ADC PARKS & GREENSPACE ARBORICULTURE

PLANNING APPLICATION: AL/74/15/TC

ADDRESS: St Mary's Church, Church Road, Aldingbourne

BRIEF DESCRIPTION: Fell 1 No. Holly tree within the Church Road
Aldingbourne Conservation Area.

Plan for Tree Work in Conservation Area

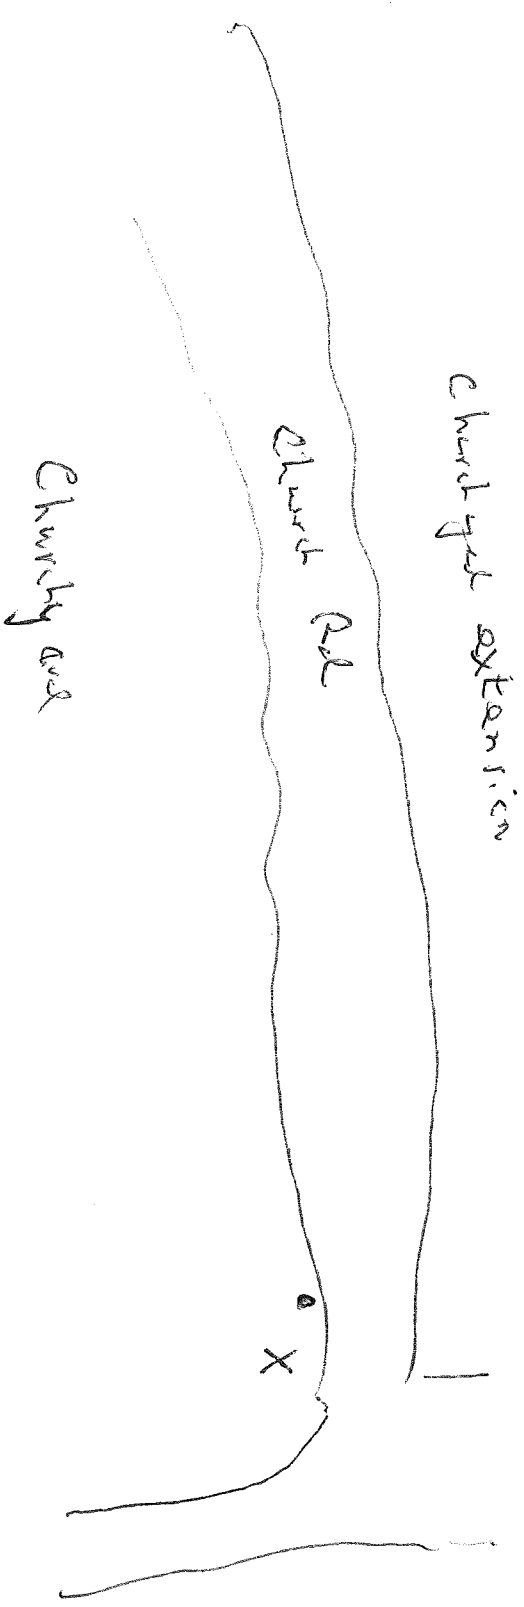
- The tree outlined in this application is located in a conservation area, and is not subject to an active TPO.
- The tree cited in this application is located in the south east corner of the church yard. From the site inspection it is clear that **T1** has a poor canopy density. It is also clear from the site inspection **T1** has had a series reductions that were of poor quality. These reductions have had negative effect on the form and the aesthetic value offered by **T1**.
- **T1** was assessed for TPO protection, and it scored a 6 on the first section of the TEMPO form, which does mean **T1** is not suitable for a TPO order.

- As **T1**, does not have the attributes to warrant a TPO order, **I would have no objection to the felling of T1.**
